24 January 2024

Sunnica Energy Development

In specific response to the SOS's letter dated 14 December and responses to same, I would comment as follows:

APPENDIX 2
PARAMETER PLANS

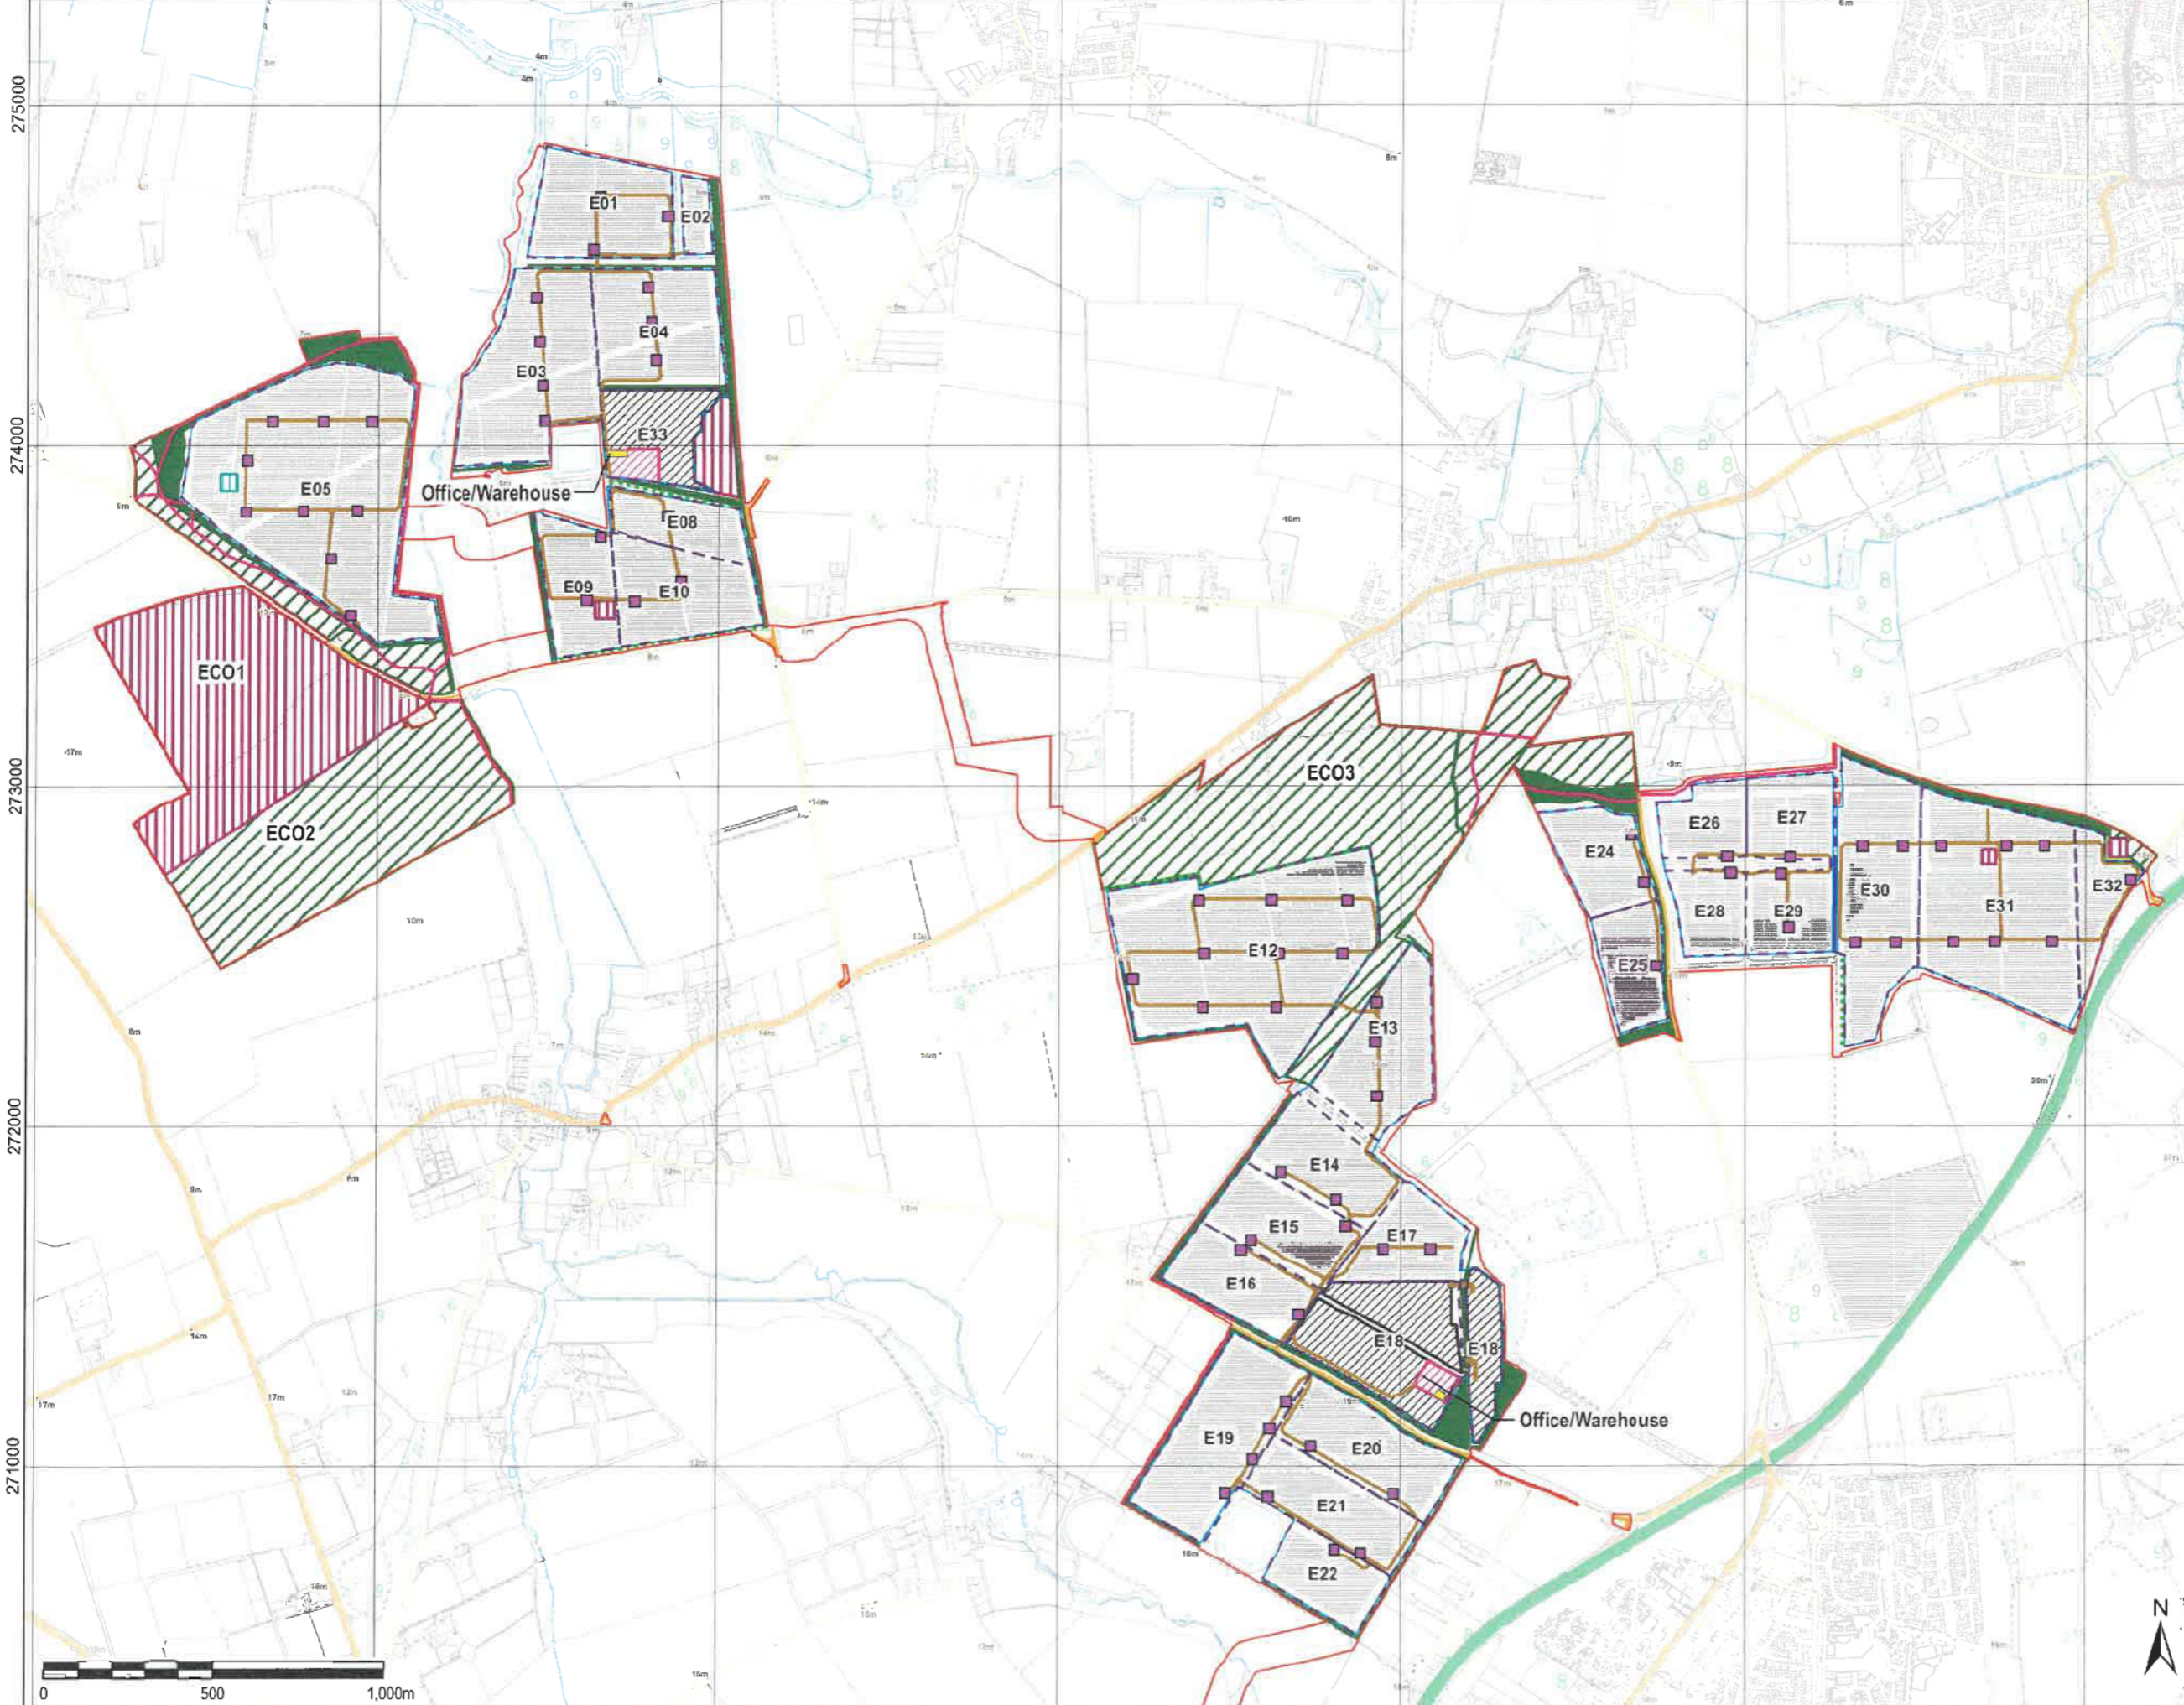
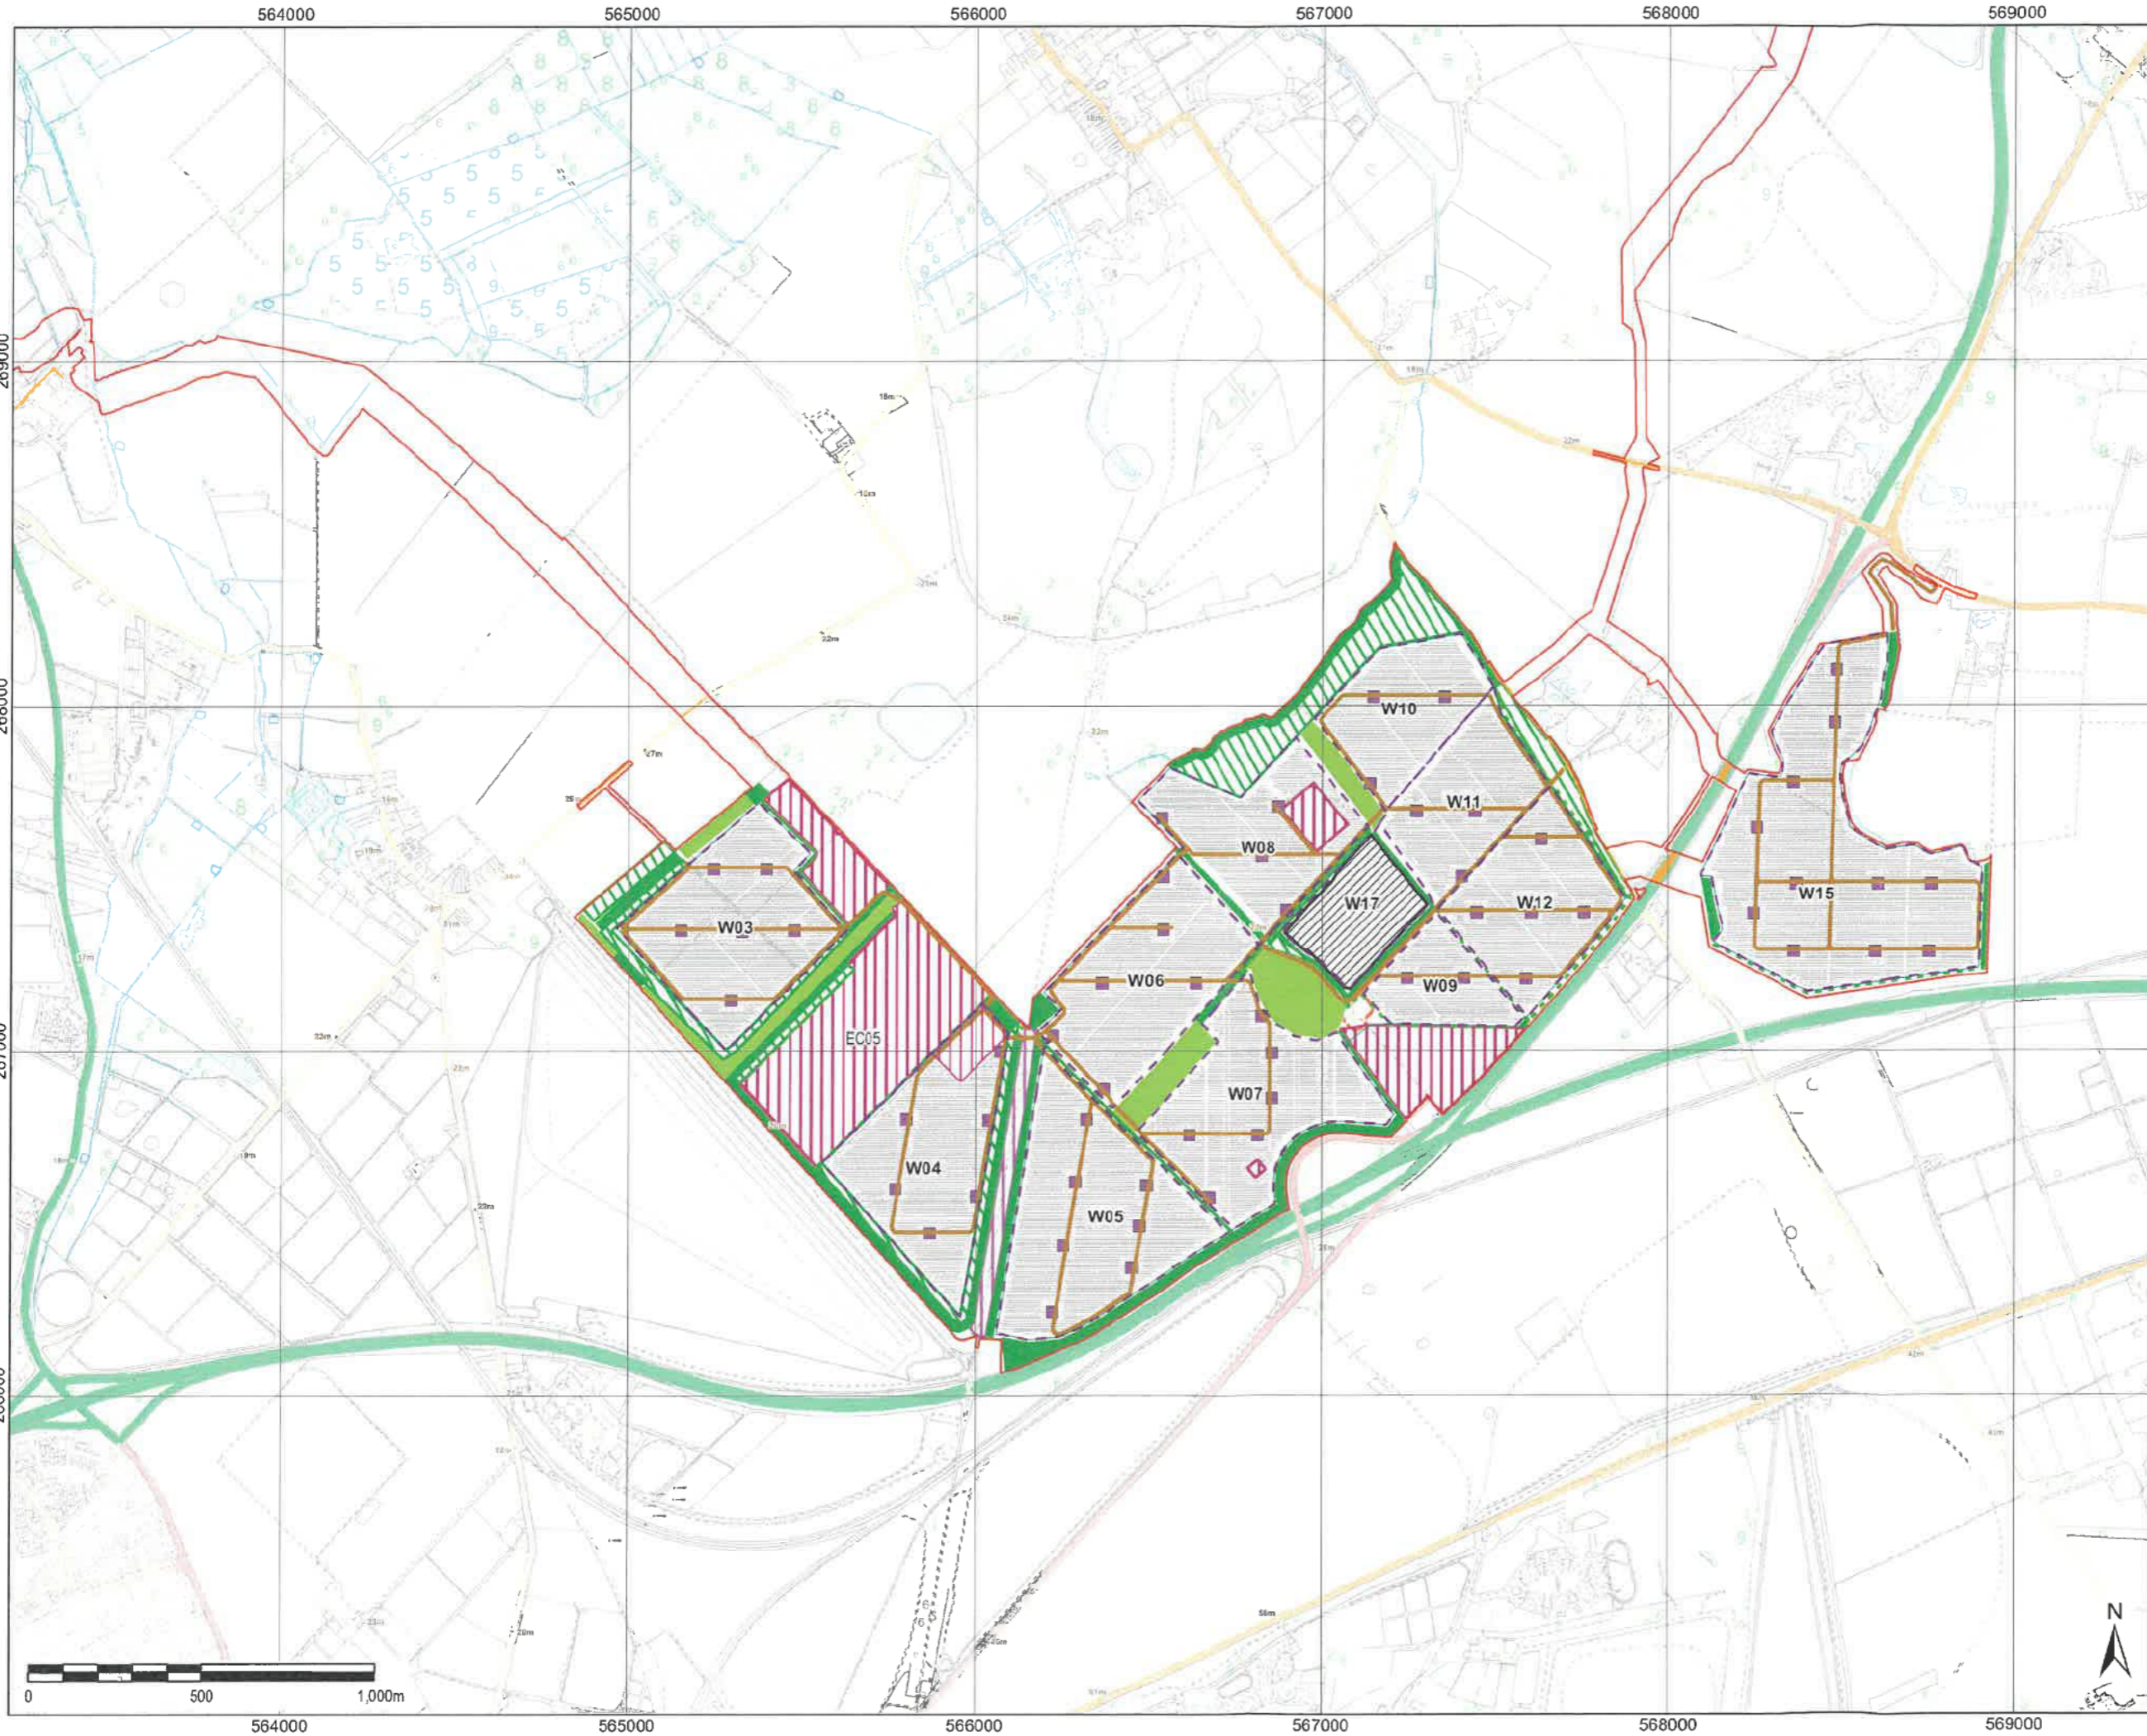
E05 - An open expanse with far reaching views and an exceptionally productive growing area (not as stated in the Applicant's assessment), the proposed planting of woodland and hedgerows is not appropriate to the existing landscape.

E05 – This site is also home to the historically significant WW2 plane crash site and a habitat for rare species including stone curlew. Any alteration to the landscape would be inappropriate.

E12 and E13, both important wildlife habitats, which lie either side of the historic Badlingham Lane (Icknield Way). Known for its ecological importance (protected trees, species, etc). The proposed cable crossing and tree removal would destroy the landscape.

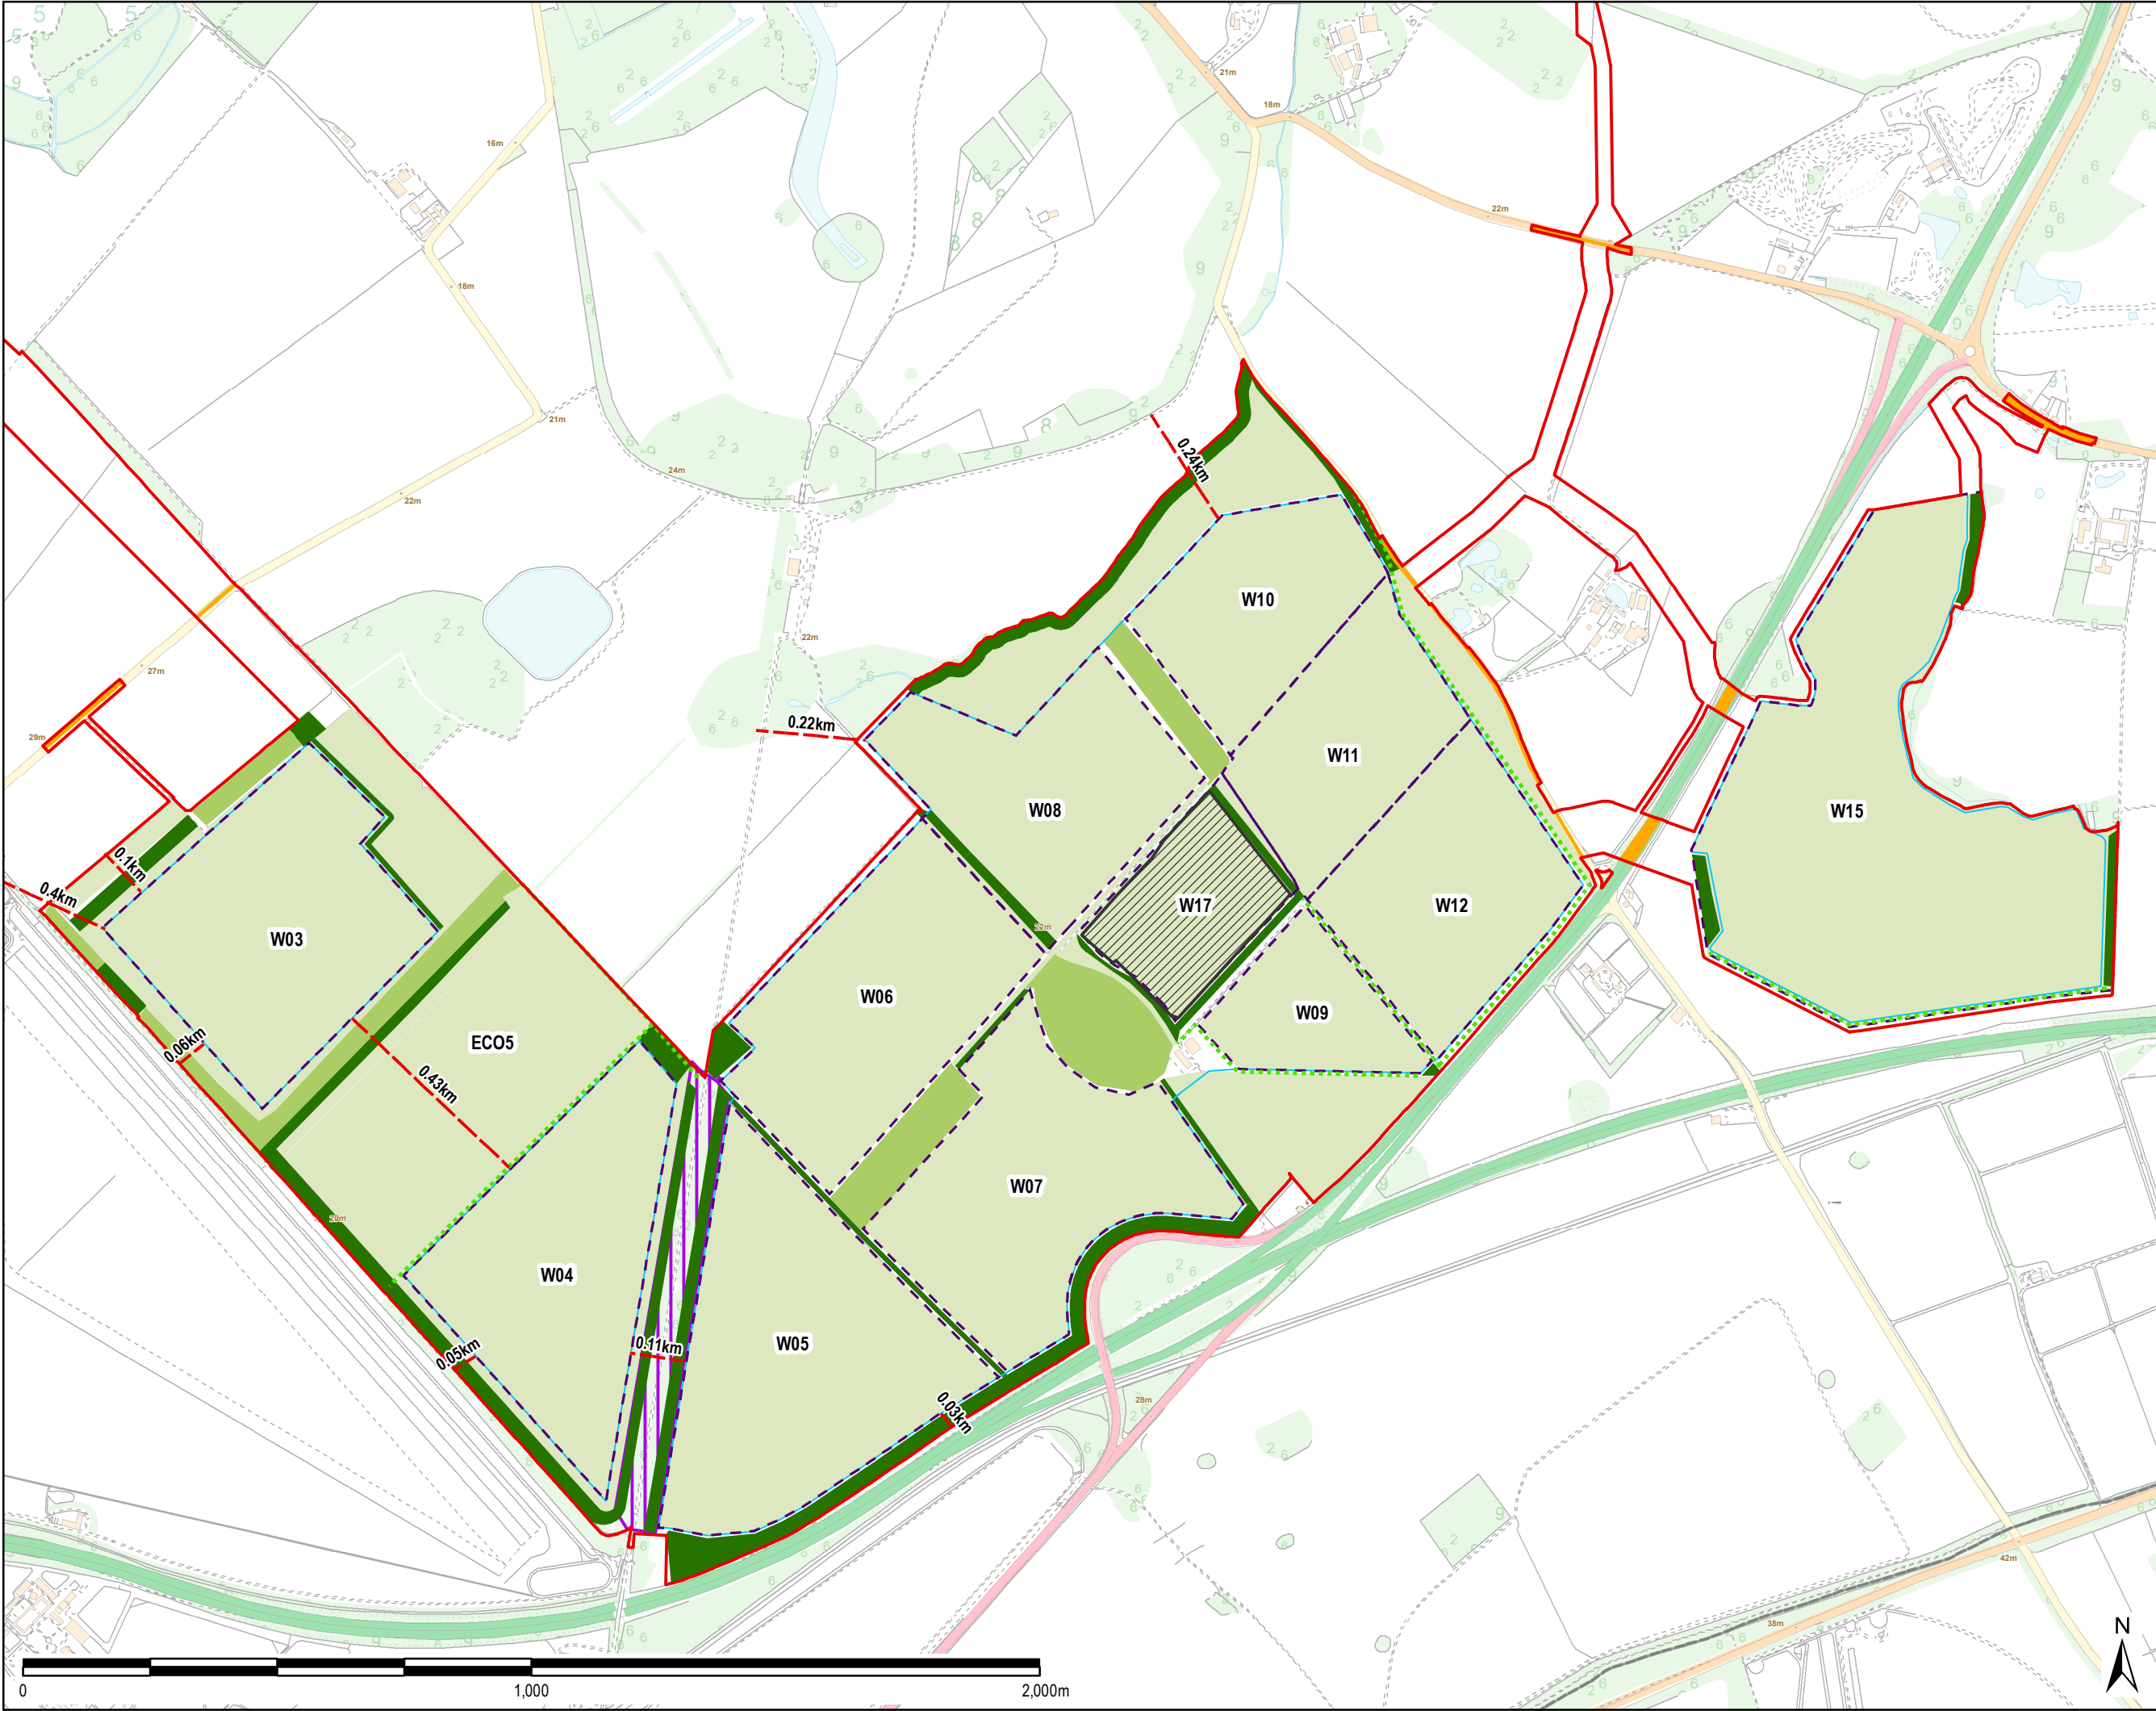
West Site A - As an elevated site, the view over West Site A from the Limekilns cannot be hidden through planting, which the Applicant themselves have agreed.
